**KIRKLEES METROPOLITAN COUNCIL
INVESTMENT & REGENERATION SERVICE**

Reference No: 2021/62/93254/W

Site Address: 52, Virginia Road, Marsh, Huddersfield, HD3 4AZ

Description: Erection of single storey rear and two storey side extension

Project:	VIRGINIA ROAD MARSH	Job No:	2021-021
TITLE: PROPOSED PLANS & ELEVATIONS			
Scale:	1:50@A1	Drawn by:	AP
Date:	30.06.21	Checked by:	-
Drawing No:	2021-021-(20)002	Revision No:	-

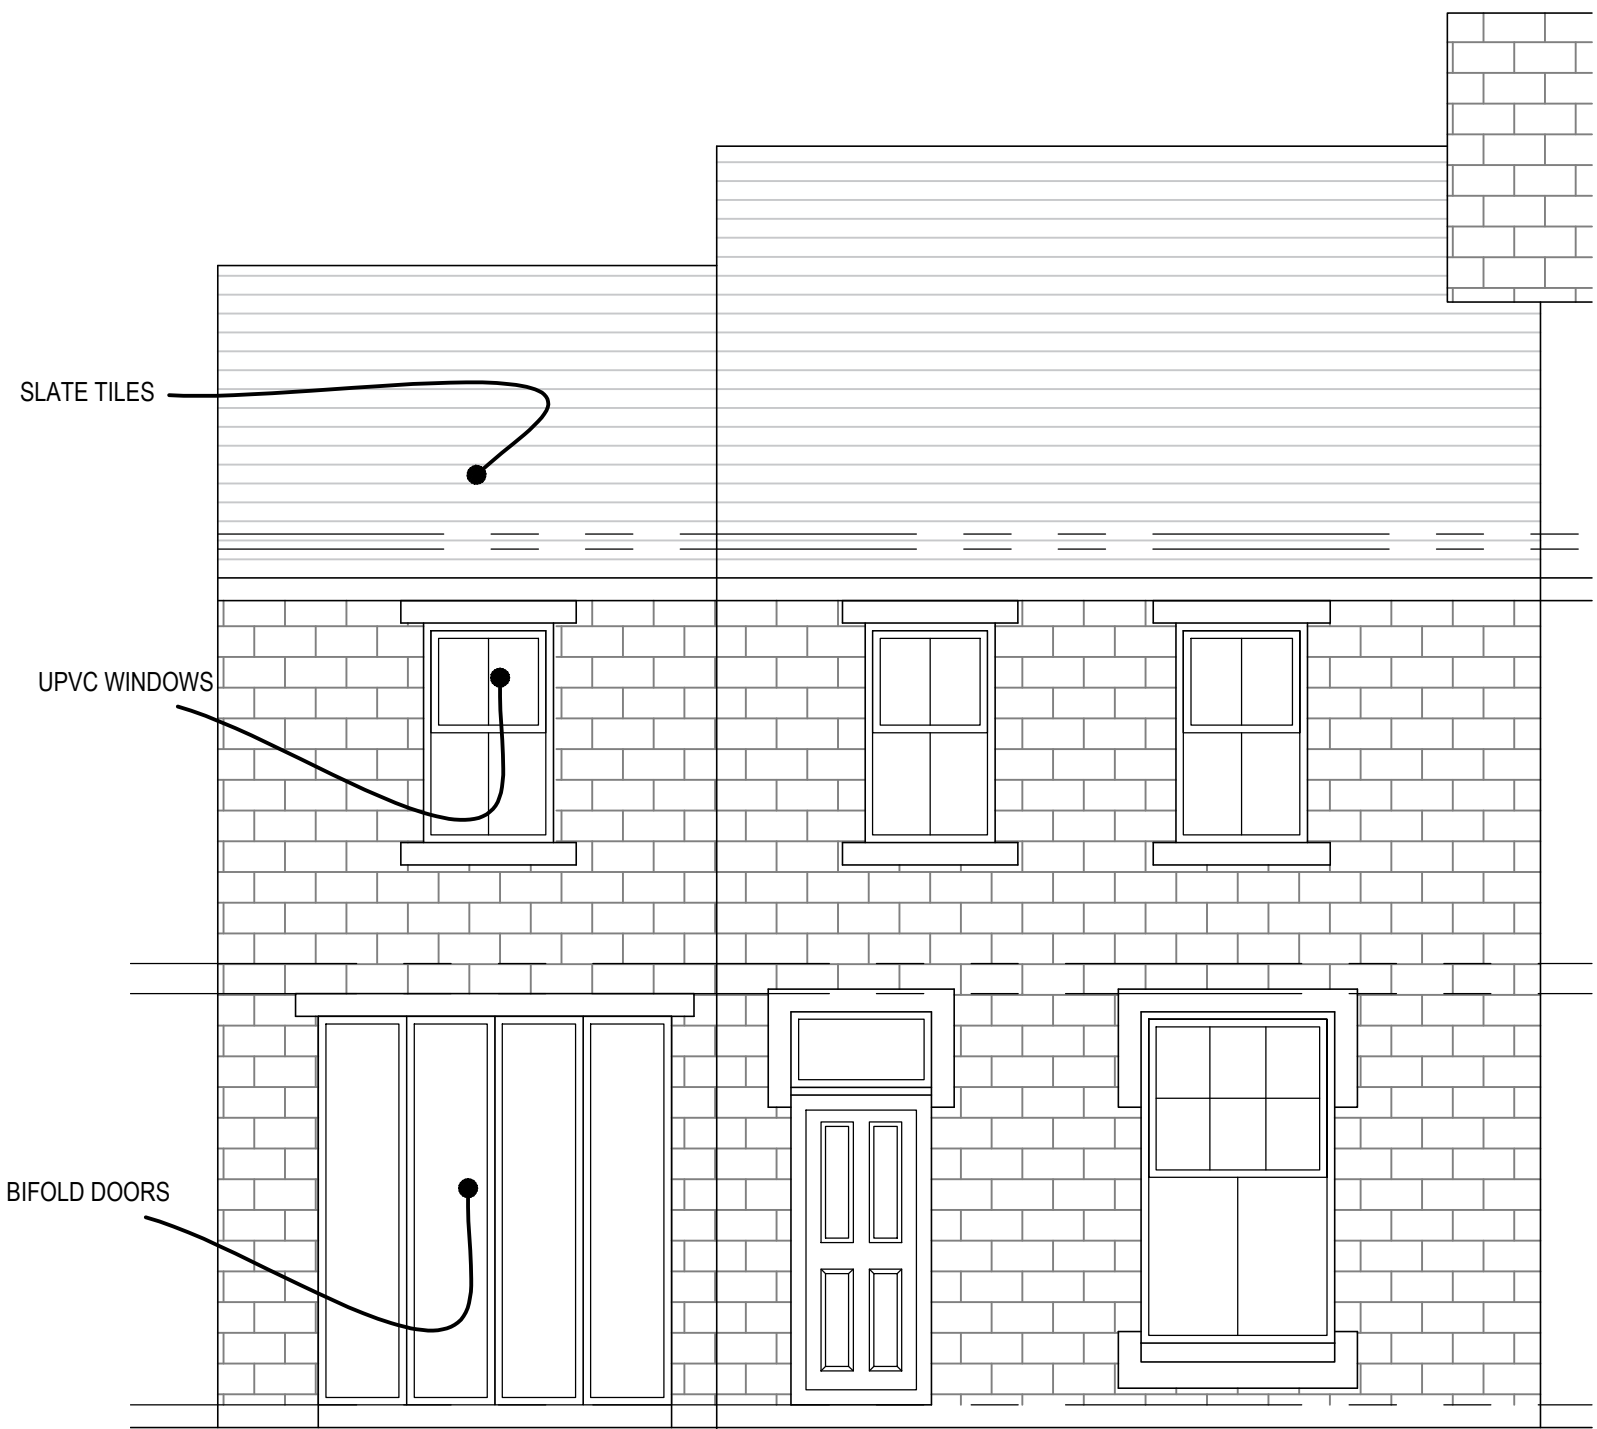
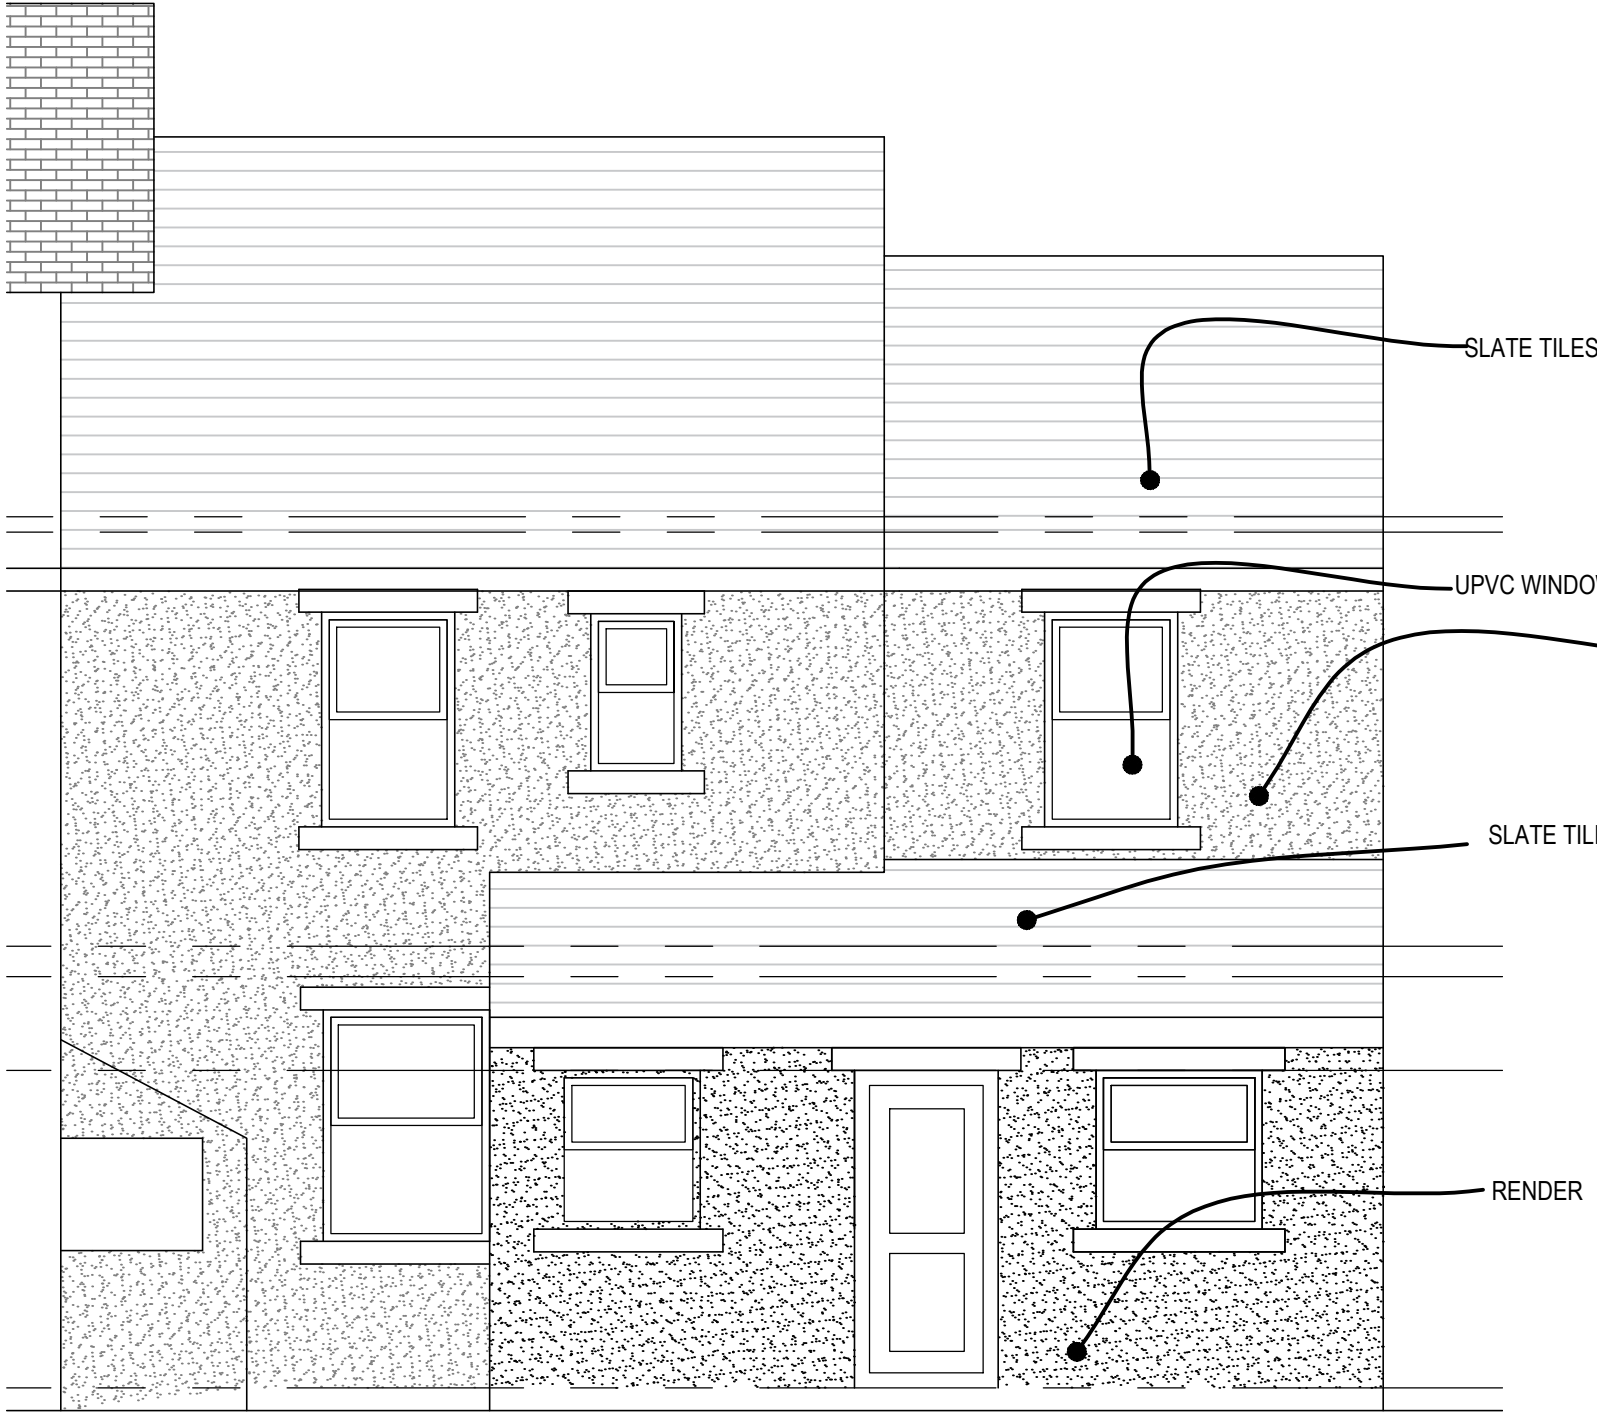
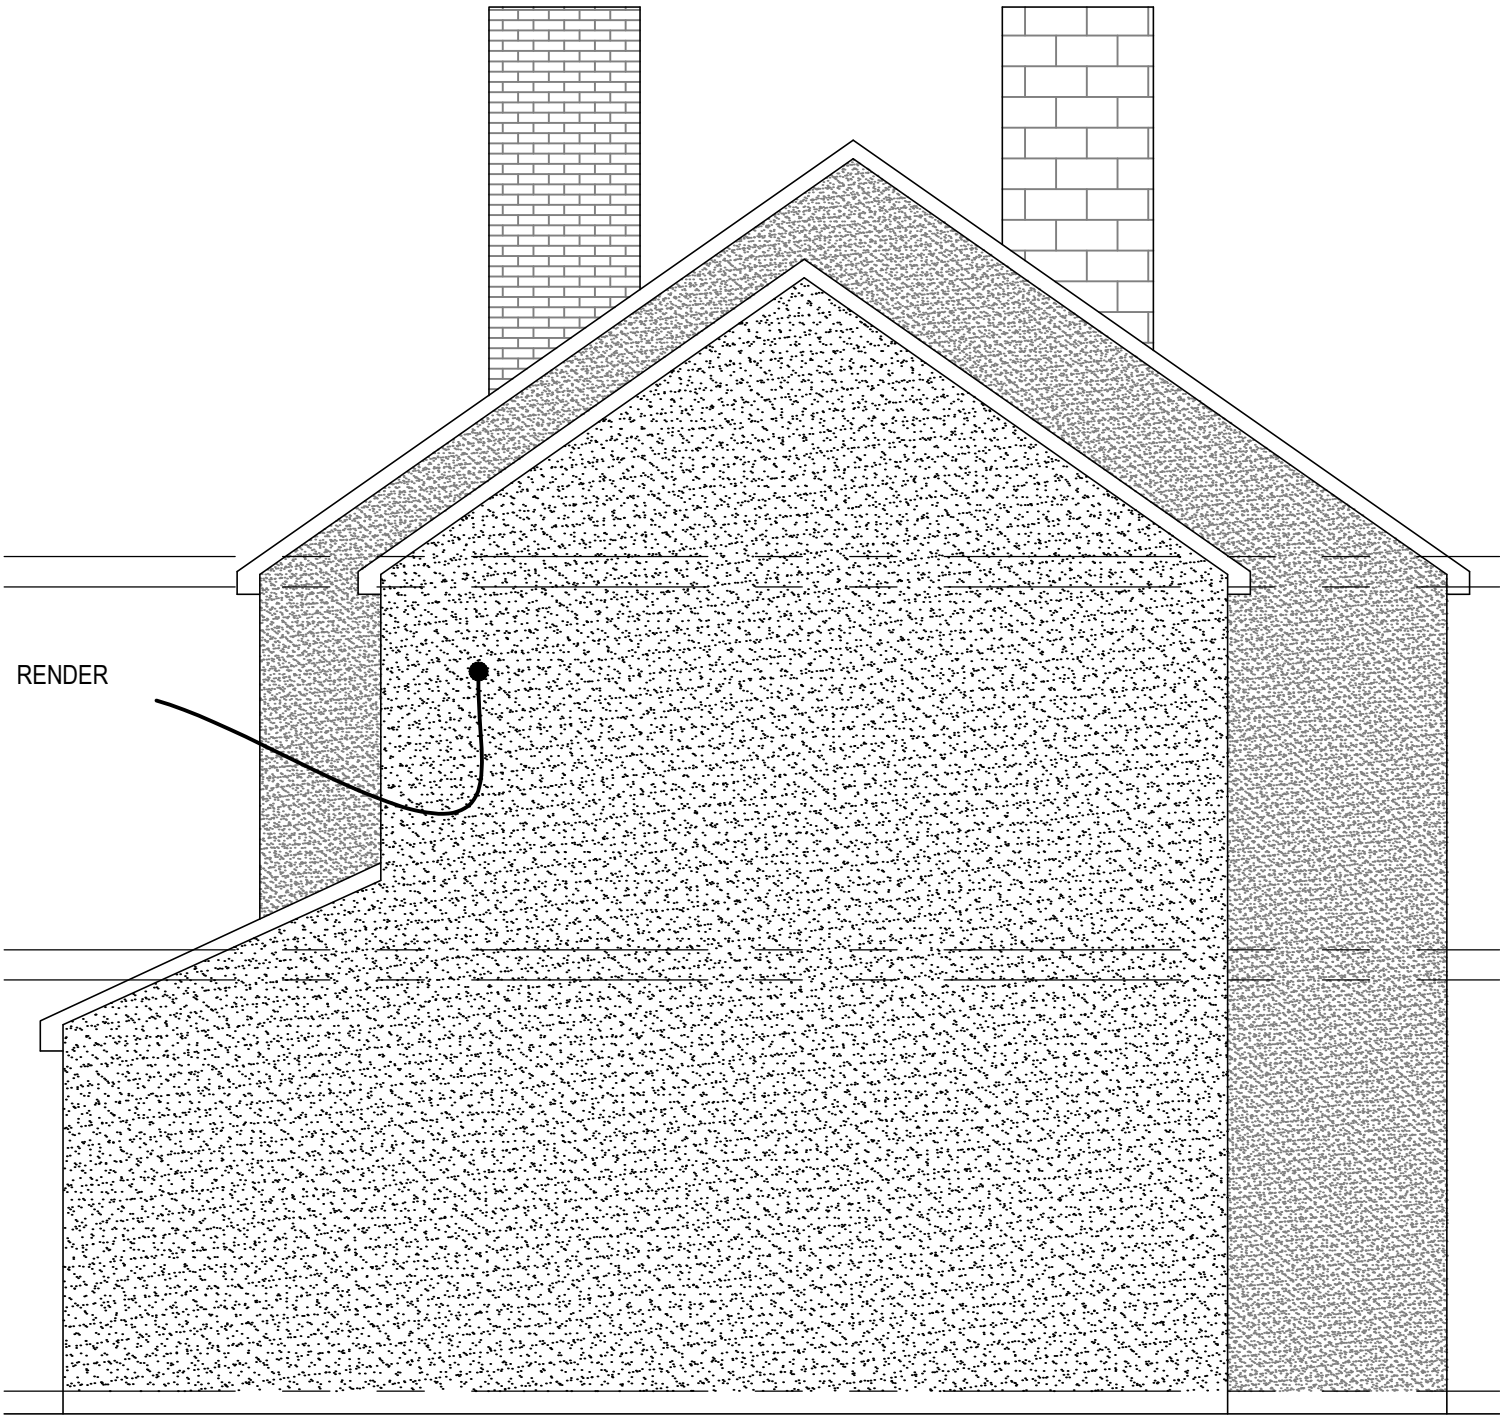
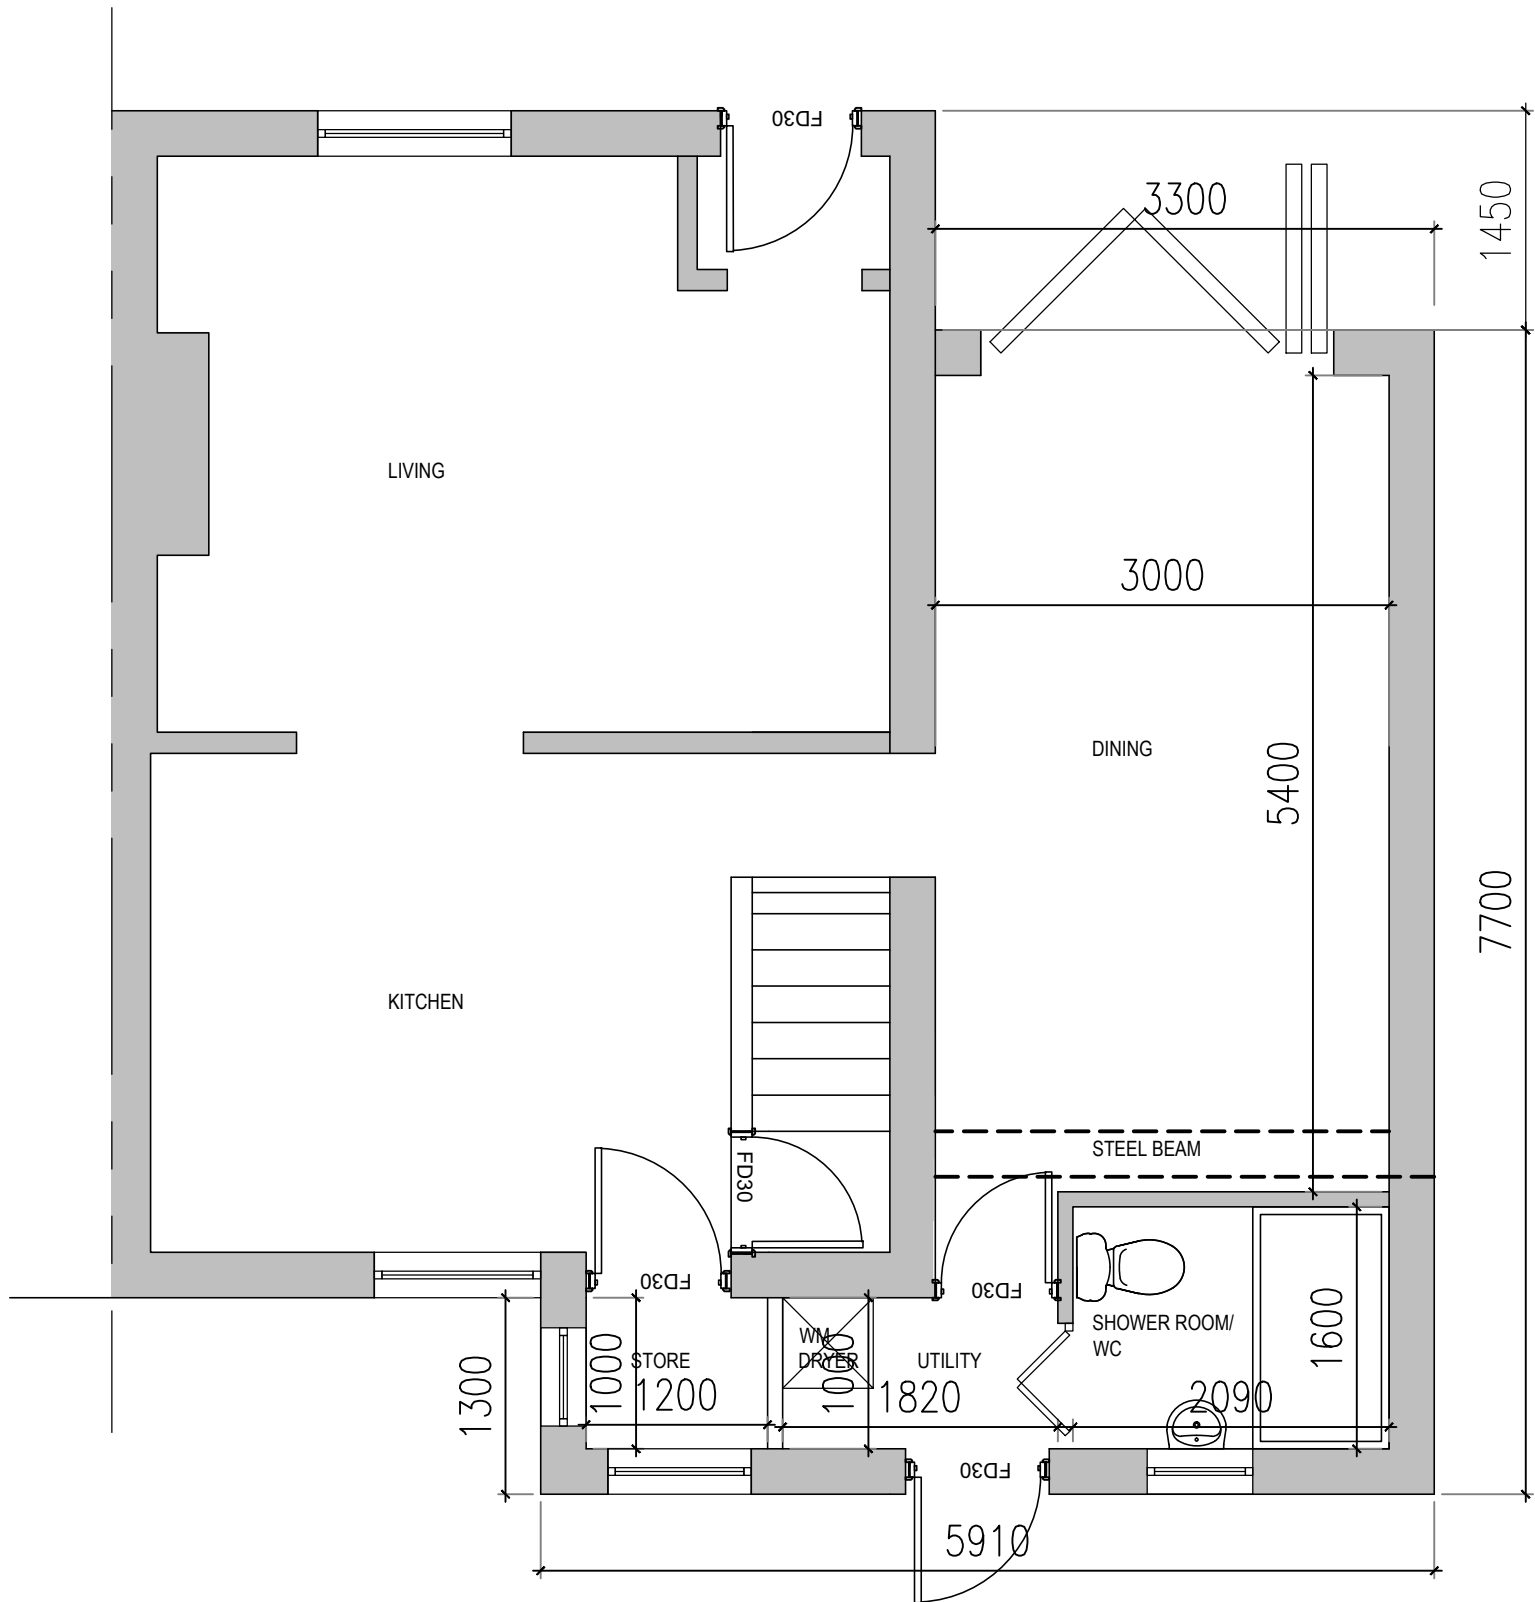
- Plans – Shared shed is not visible on proposed and is visible on the proposed rear elevation. An objection was raised on the removal of this shed.

Officer Note: Plans correspond with each other, the shed is to be demolished on No. 52's side. This is a private matter and not a planning consideration. A footnote has been attached for clarity.
